5 April 2022

DESIGN INTEGRITY PANEL BRIEFING AND COMMENTS

On Wednesday 23 March 2022 Gurner and its consultants briefed the Design Integrity Panel in relation to the design changes arising between the PTW winning mixed use BTS tower and the proposed mixed use BTR tower.

Title
C-FACADE DETAILS
PODIUM FACADE DETAILS

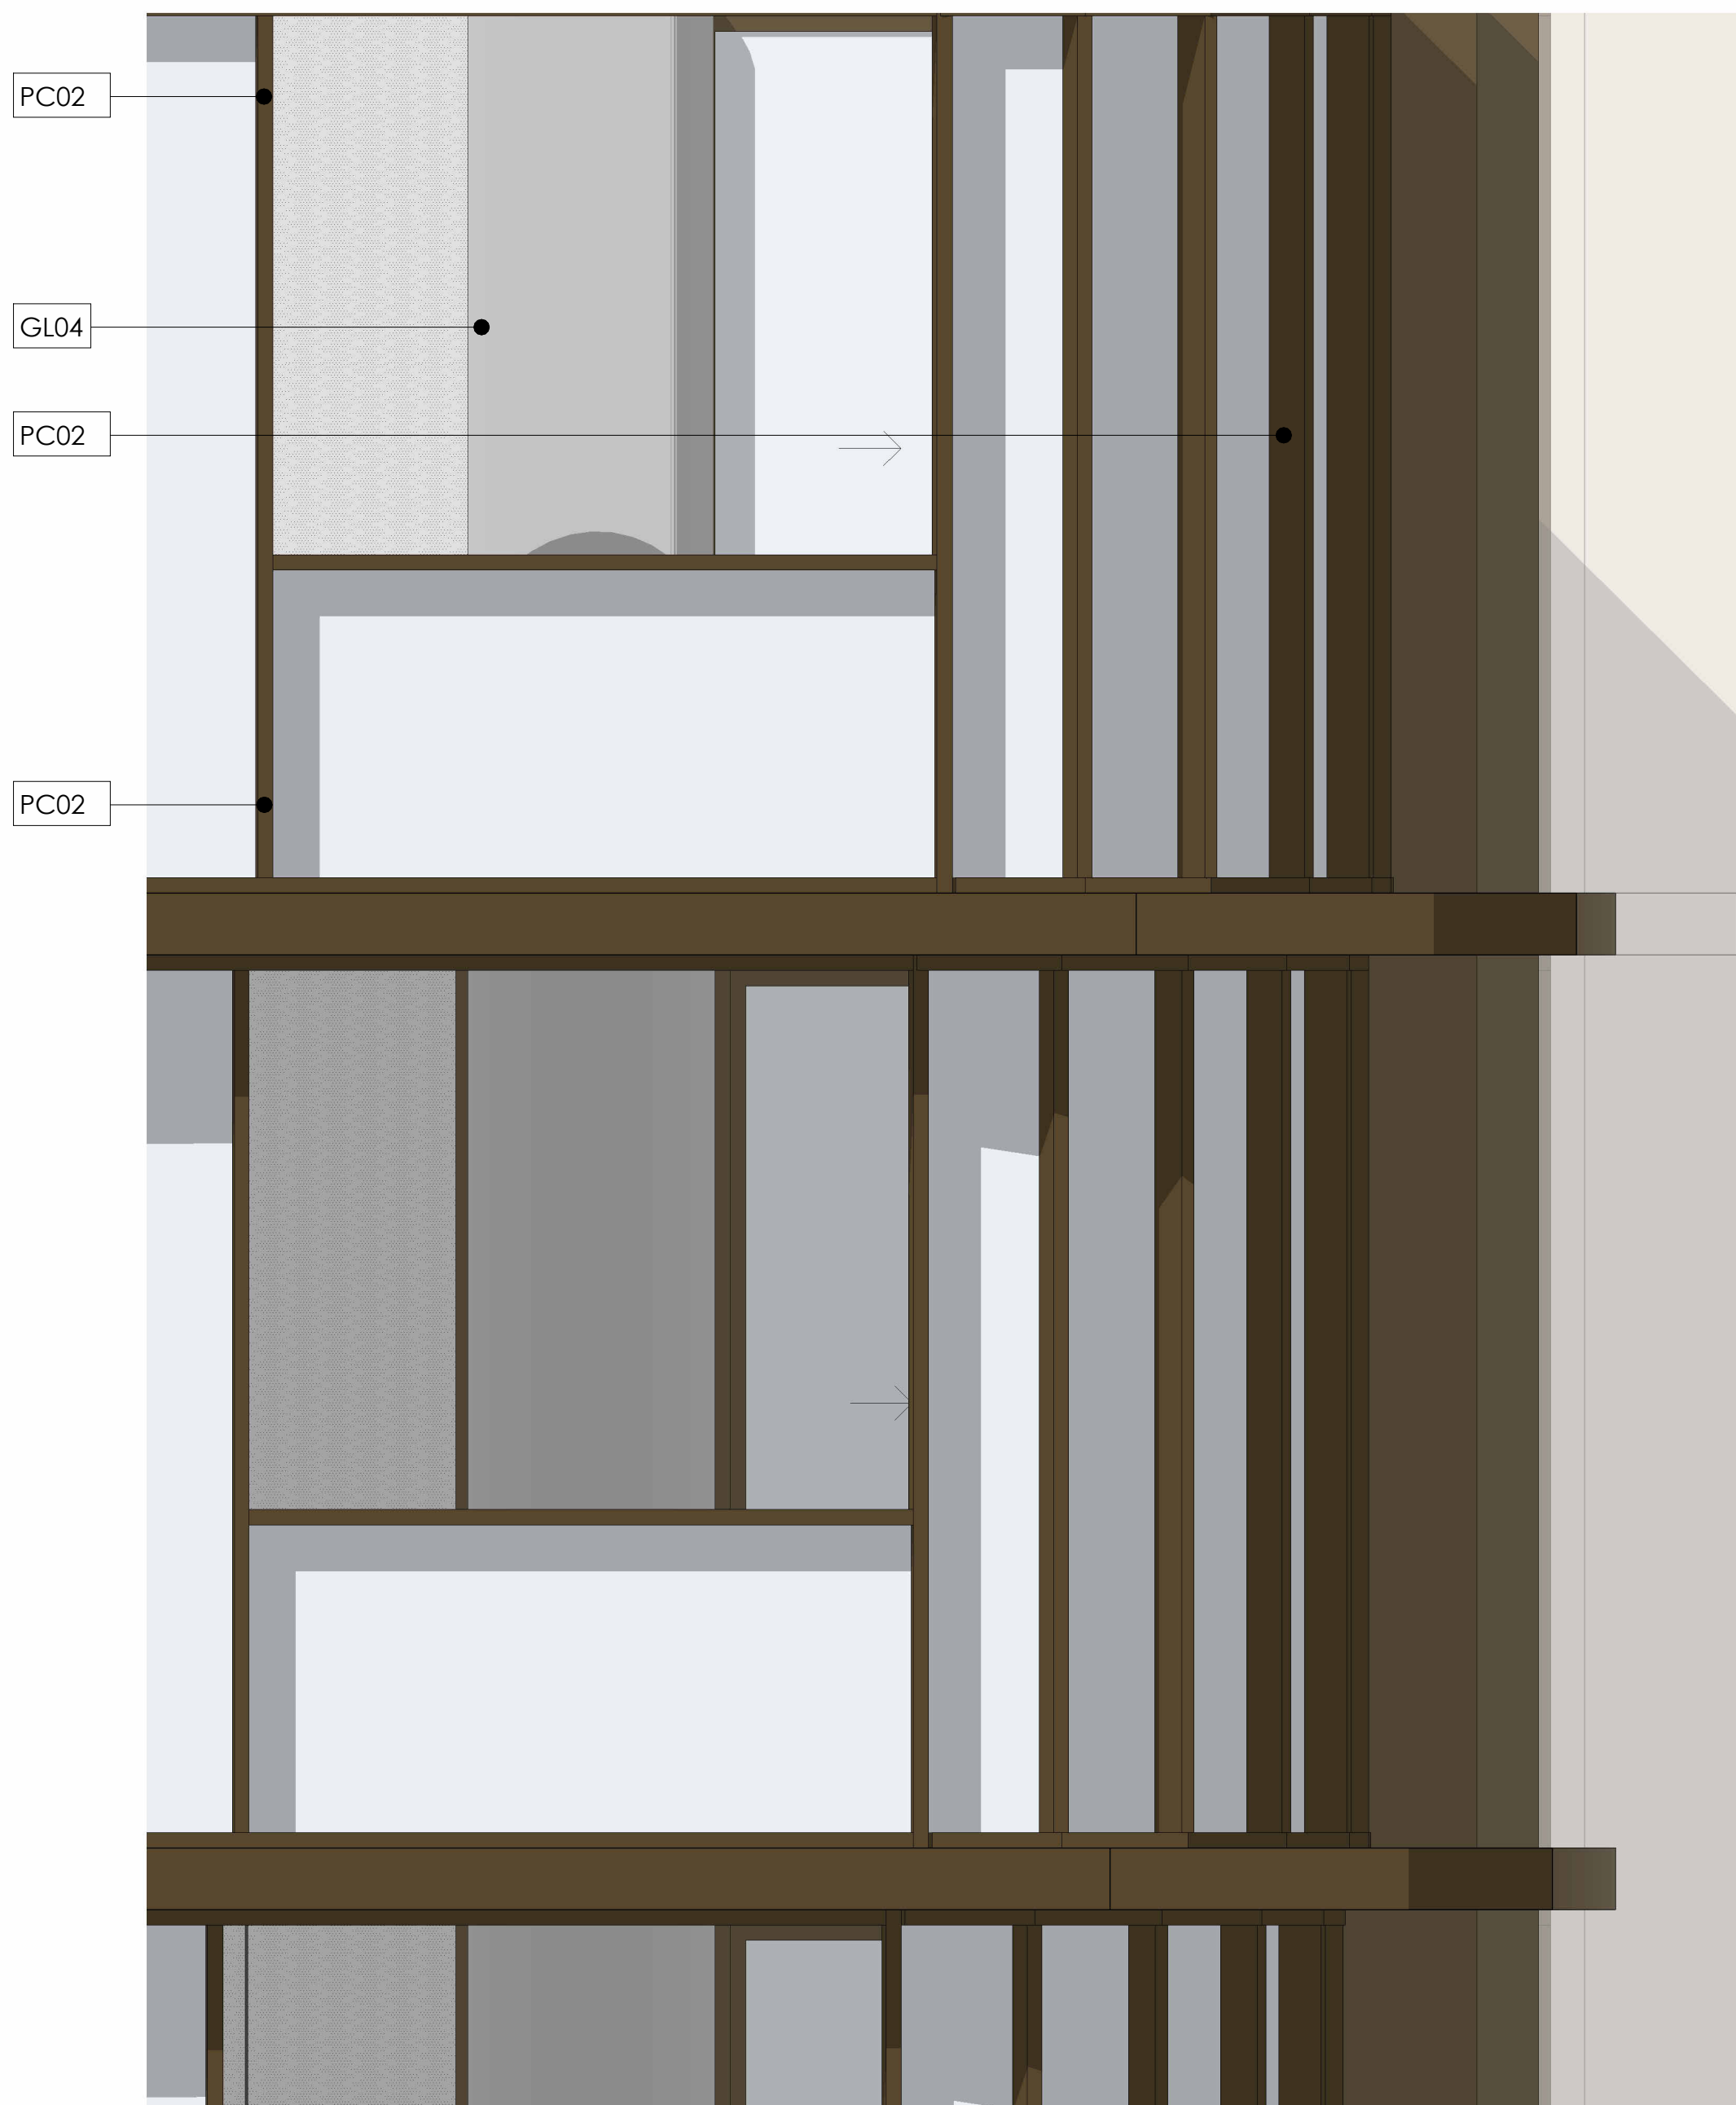
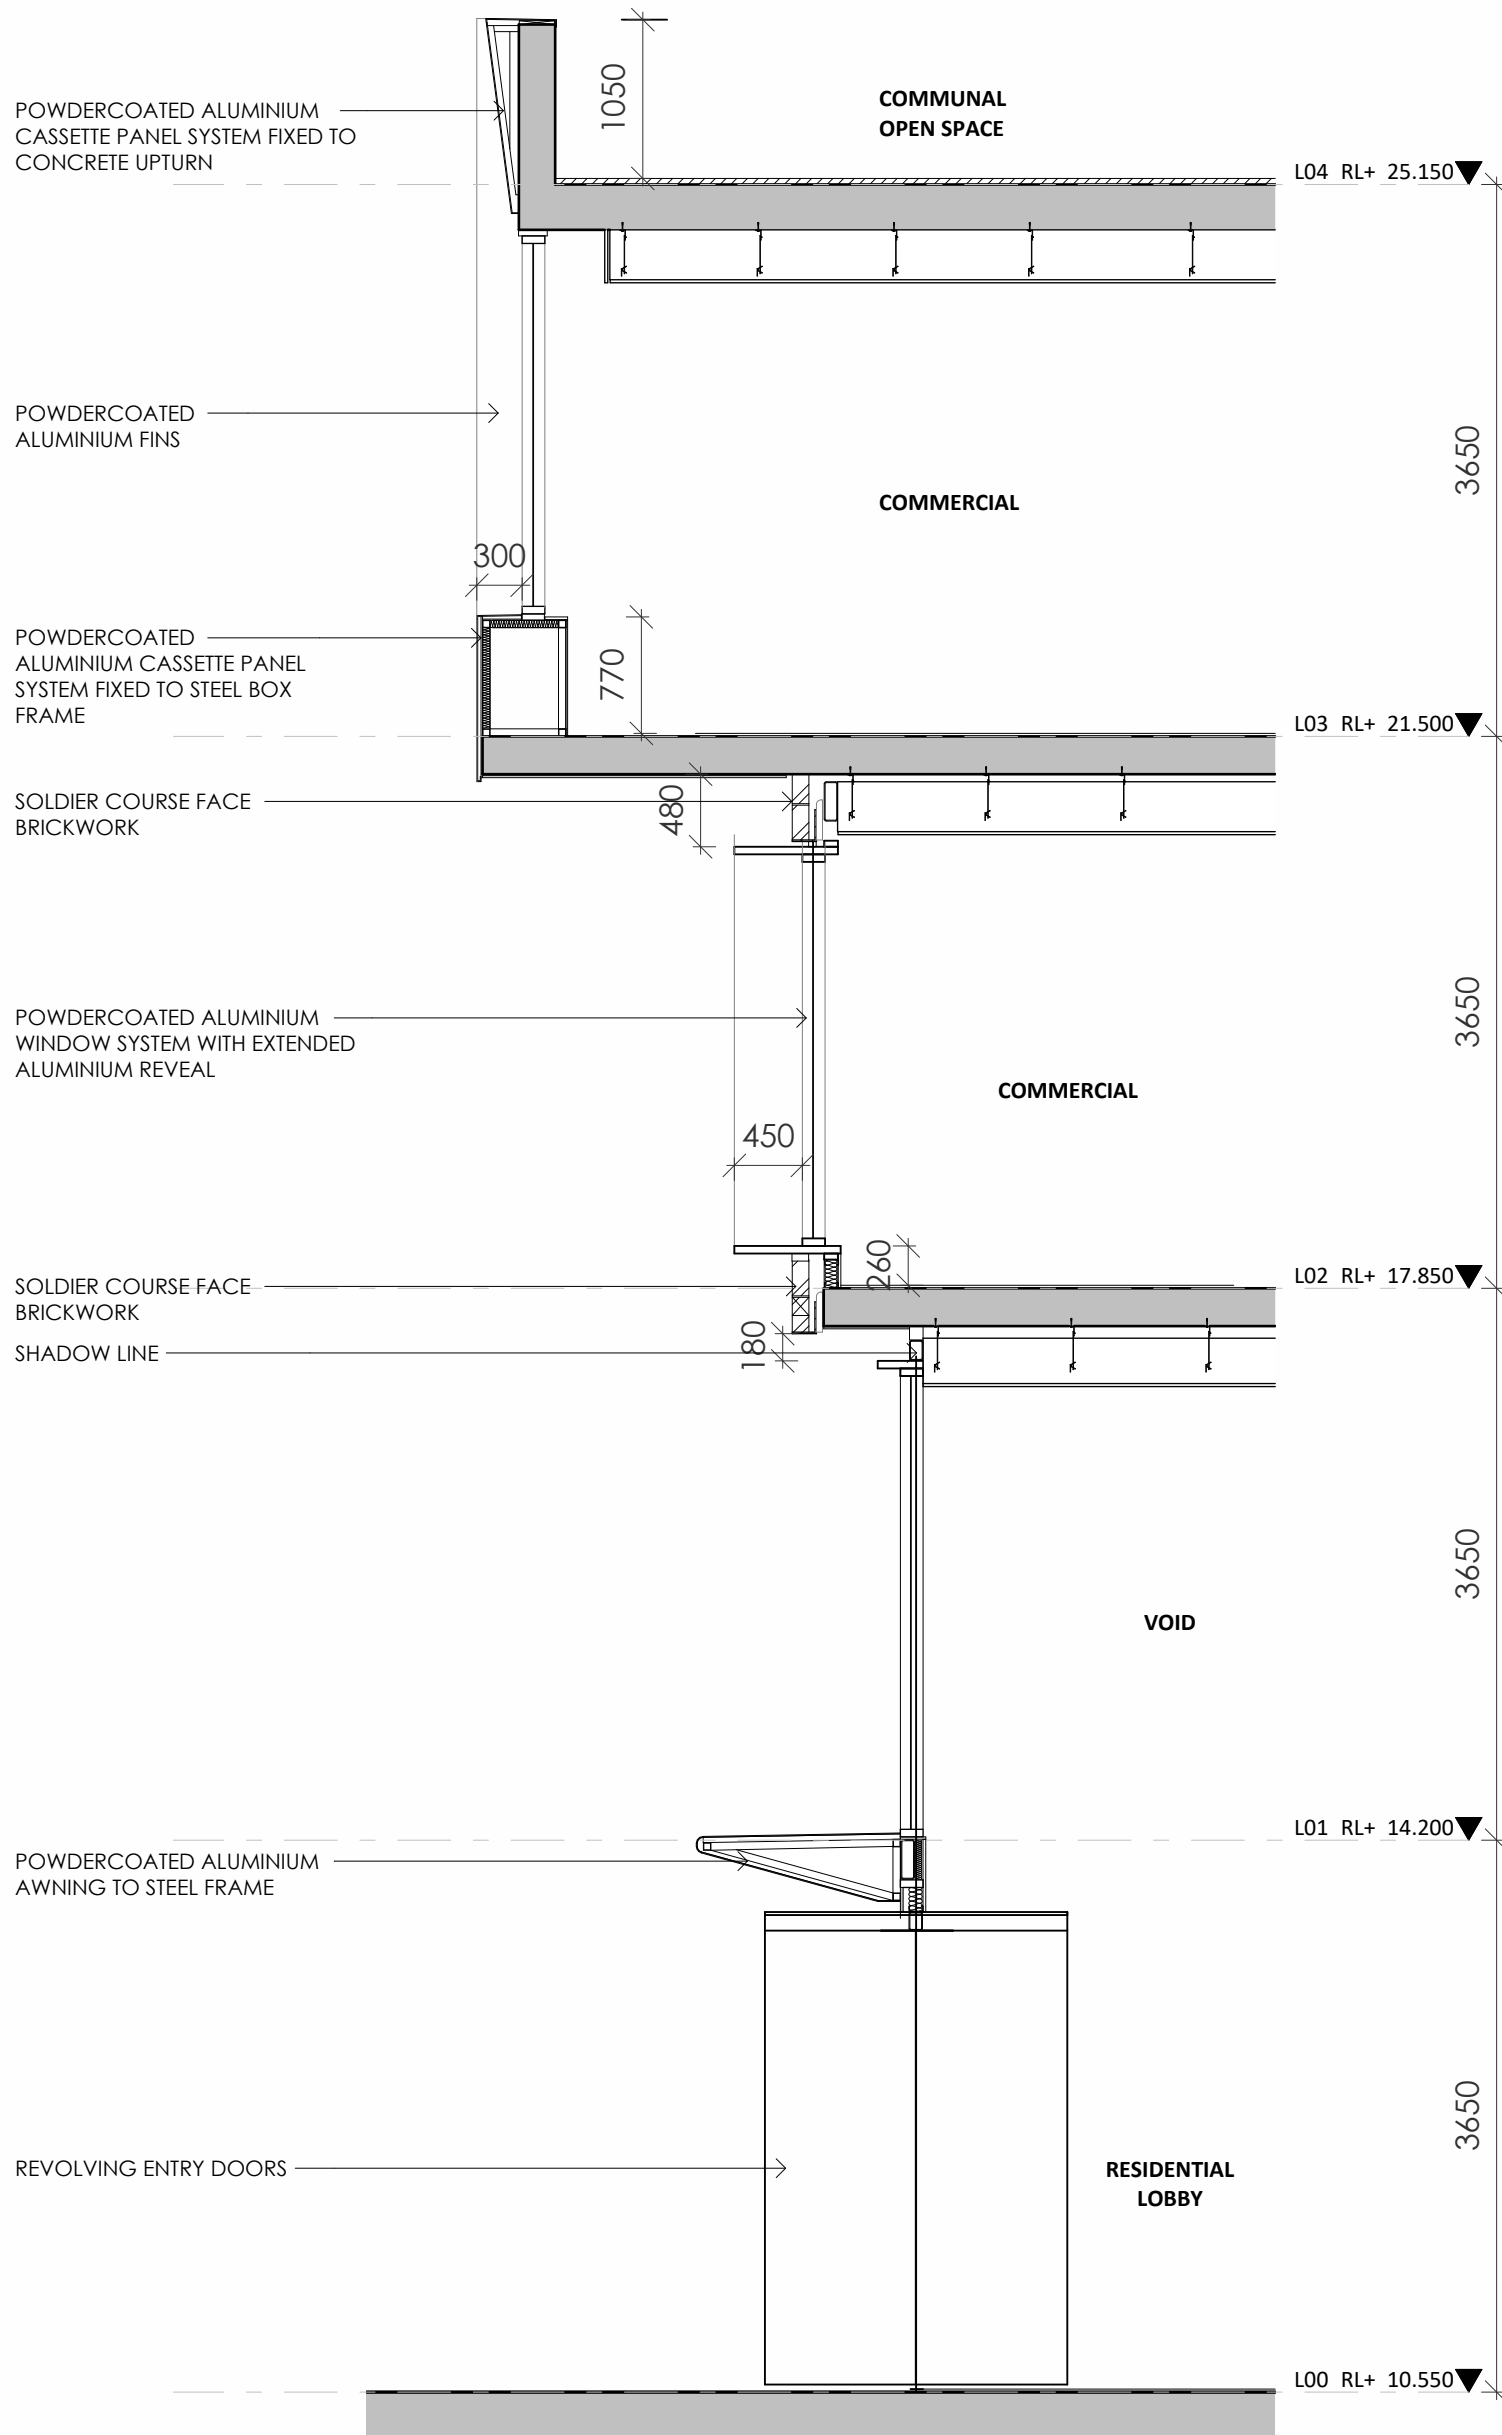
- Summarise the key changes to the podium. What are these changes and how has design excellence been retained?
- The podium design seems to comprise a higher level of glazing, please clarify and explain design implications.
